City of Portland
Development Review Application
Planning Division Transmittal Form

Application Number: 2016-195 **Application Date:** 08/23/2016
CBL: 020 B014001 **Application Type:** Administrative Authorization

Project Name: Dormer Addition
Address: 45- HANCOCK ST
Project Description: Add dormers to create 1 additional unit to go from 5 to 6 units in the building.

To: FILE
From: Caitlin Cameron
Subject: Application ID: 2016-195
Date: 2/3/2017

ELEVATIONS

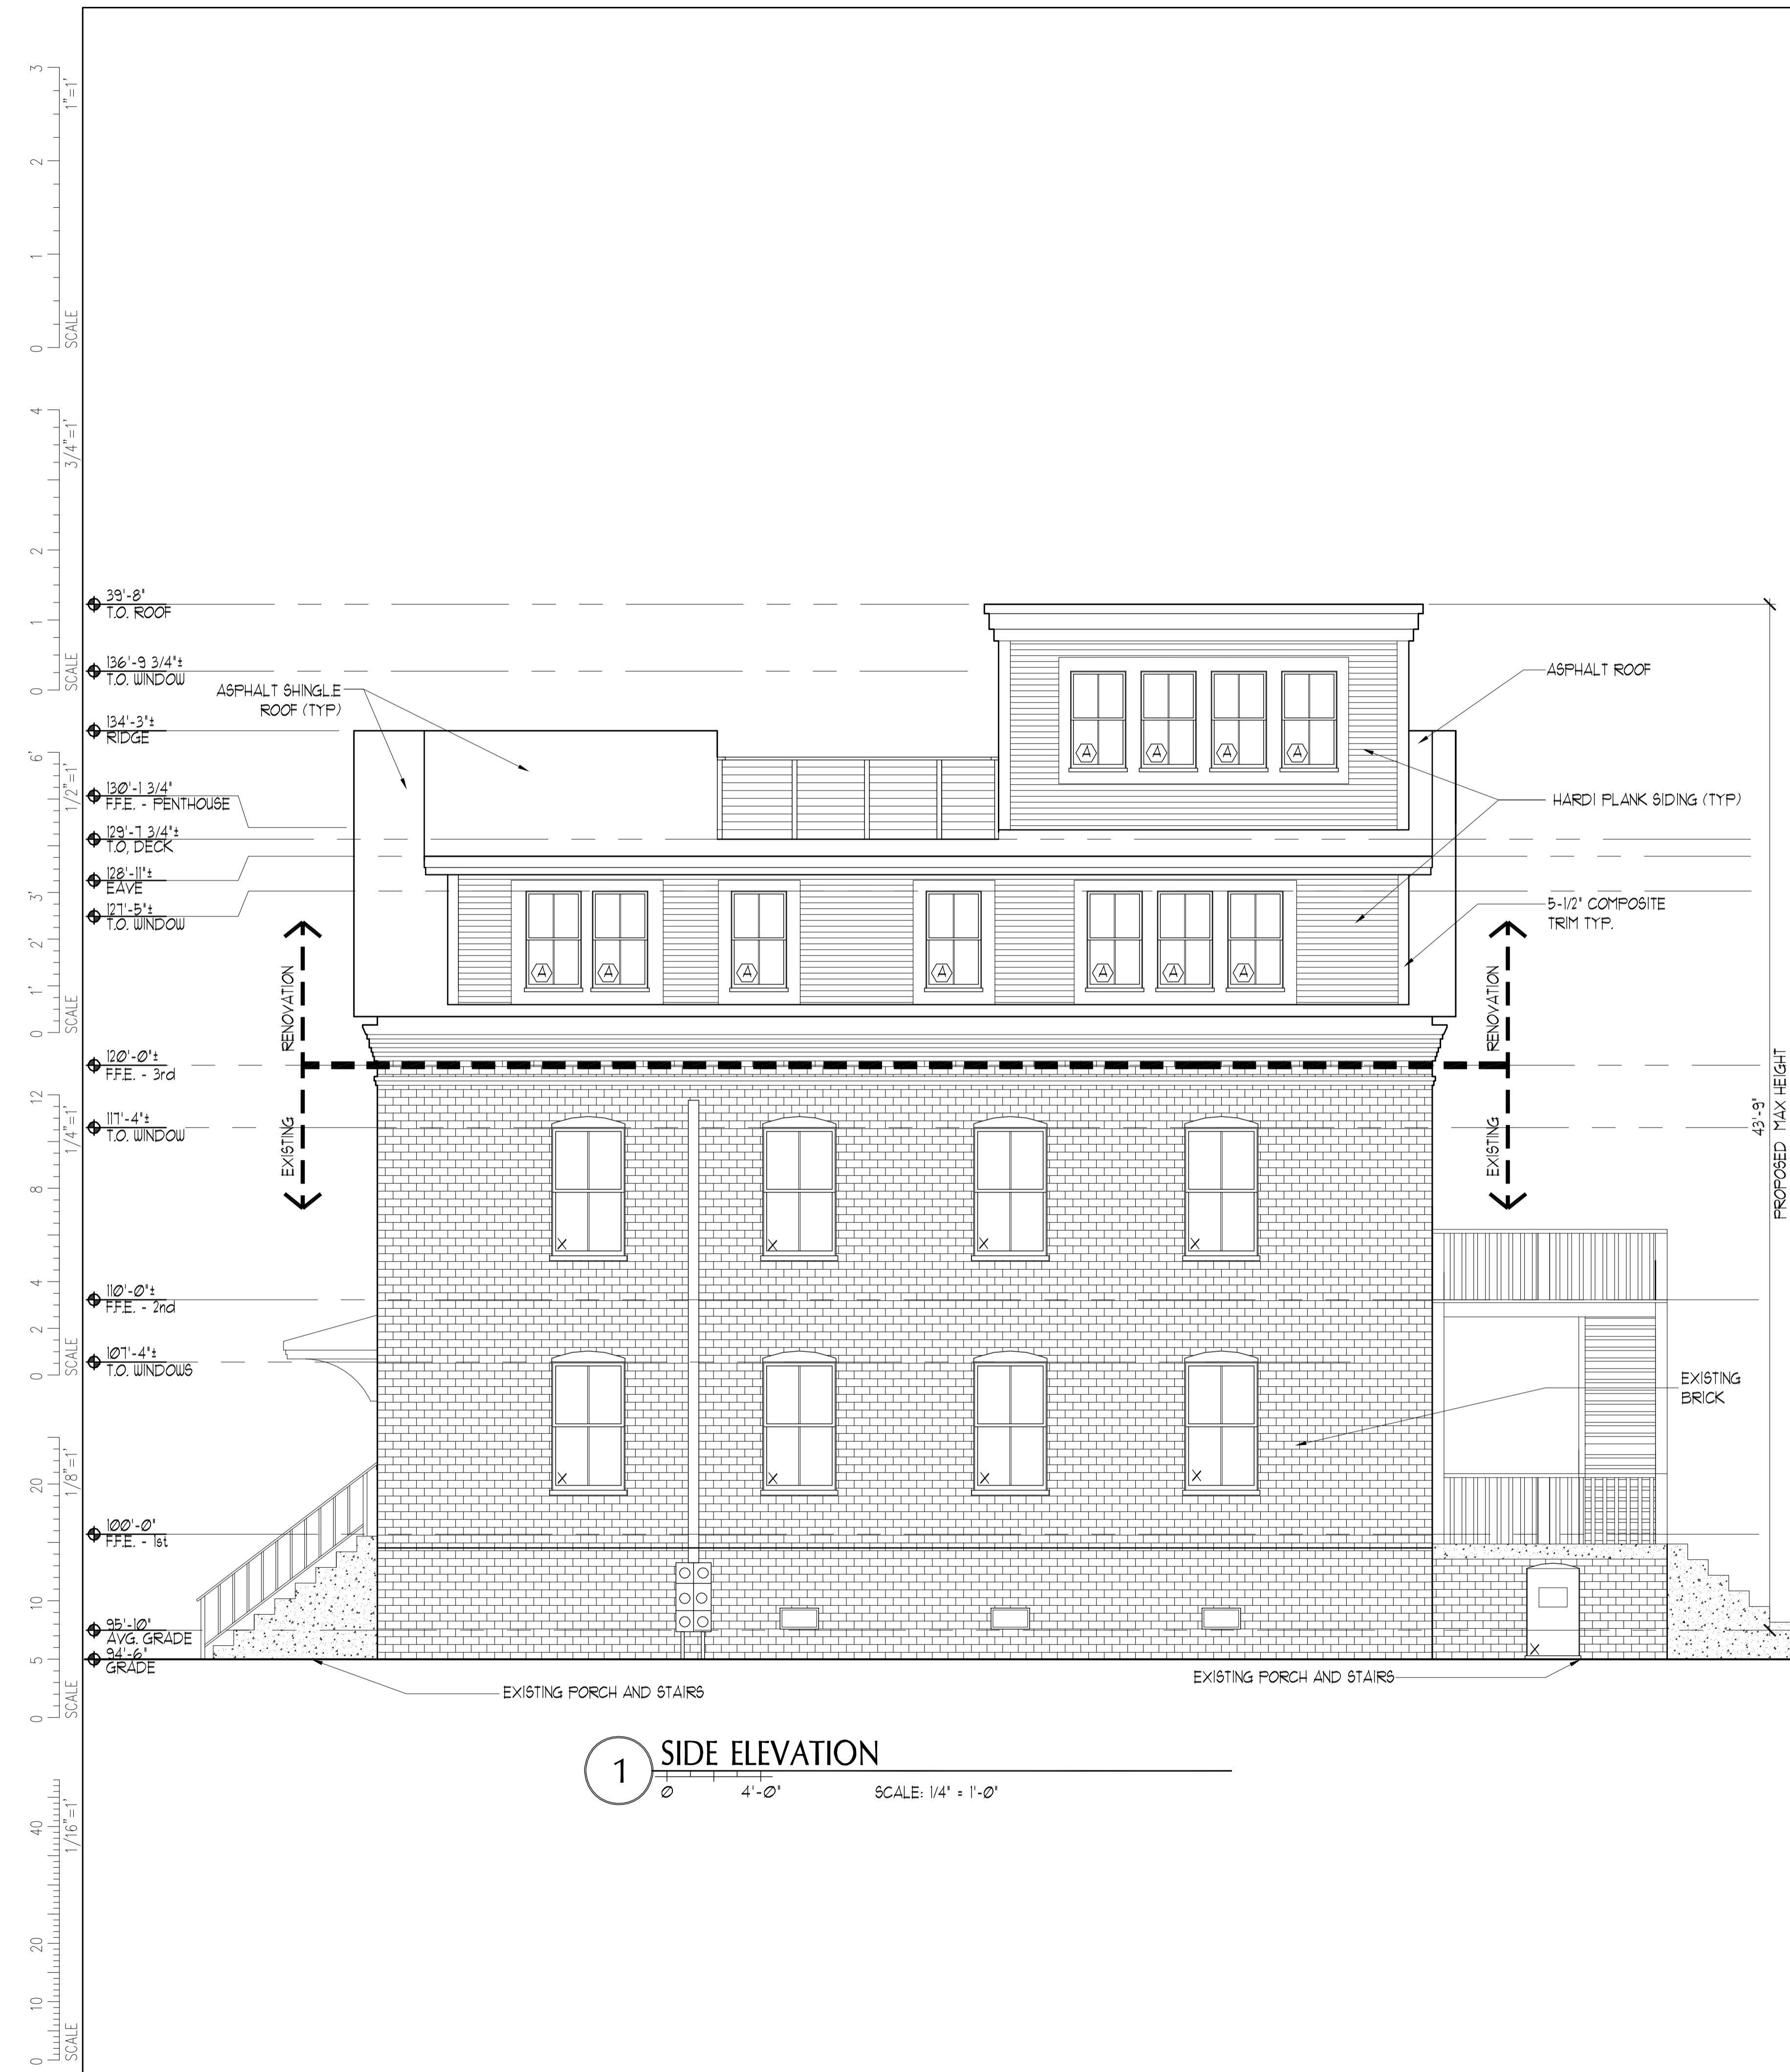
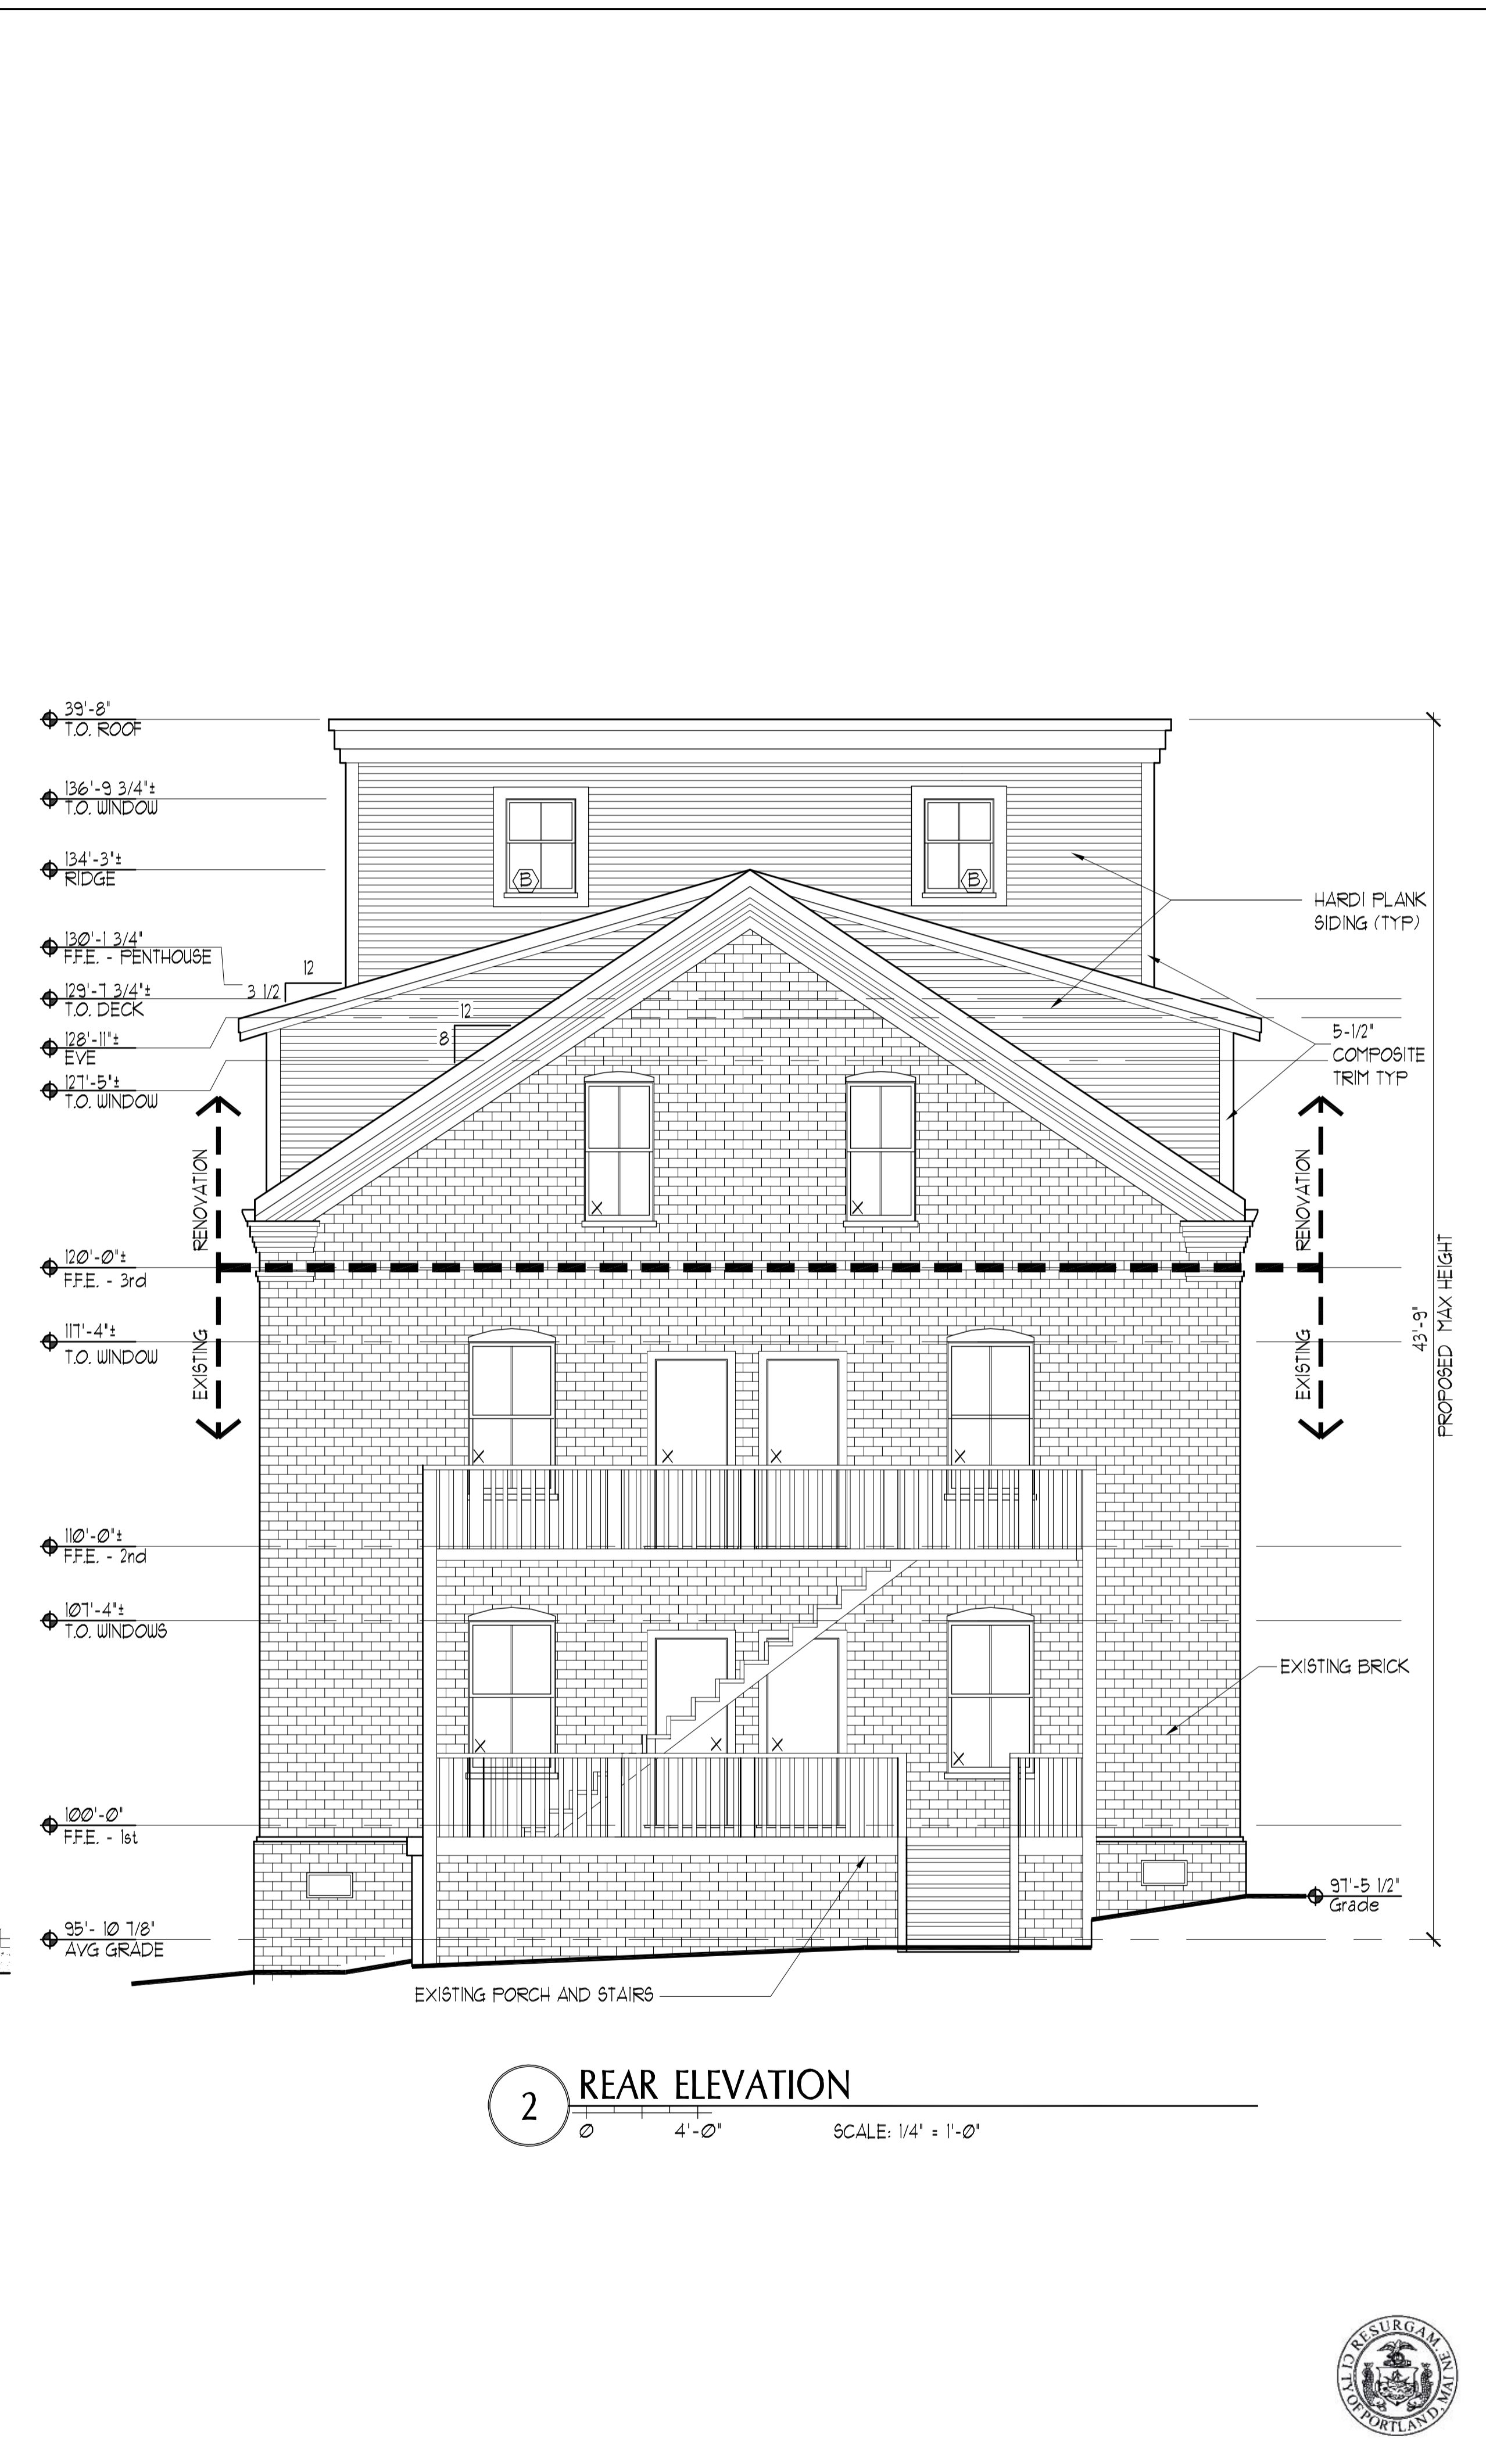
The revisions were made to top-most level to reduce the visibility and impact of the addition to the streetscape and cemetery. Staff supports the flat roof, additional windows, and the grey color to minimize the visual impact. The original building form and detail remain the central focus with this revised design – darker or grey color palette especially helps the addition recede and keep the emphasis on the historic original building.

7. Roof Lines					
Intent	<input checked="" type="checkbox"/>	<input type="checkbox"/>	<input type="checkbox"/>	<input type="checkbox"/>	Character: The surrounding character is simple roof forms. Views: The proposed addition design was revised to minimize the impact on views.

Guidelines	<input checked="" type="checkbox"/>	<input type="checkbox"/>	<input type="checkbox"/>	<input type="checkbox"/>	<p>The dustpan dormers are adequately integrated, especially helpful that it is setback from the main roof at the street face to reinforce that it is the secondary roof.</p> <p>Revisions were made to top-most level to reduce the visibility and impact of the addition to the streetscape and cemetery. Staff supports the flat roof, additional windows, and the grey color to minimize the visual impact.</p>
Standard 7.1	<input type="checkbox"/>	<input type="checkbox"/>	<input type="checkbox"/>	<input checked="" type="checkbox"/>	
Standard 7.2	<input checked="" type="checkbox"/>	<input type="checkbox"/>	<input type="checkbox"/>	<input type="checkbox"/>
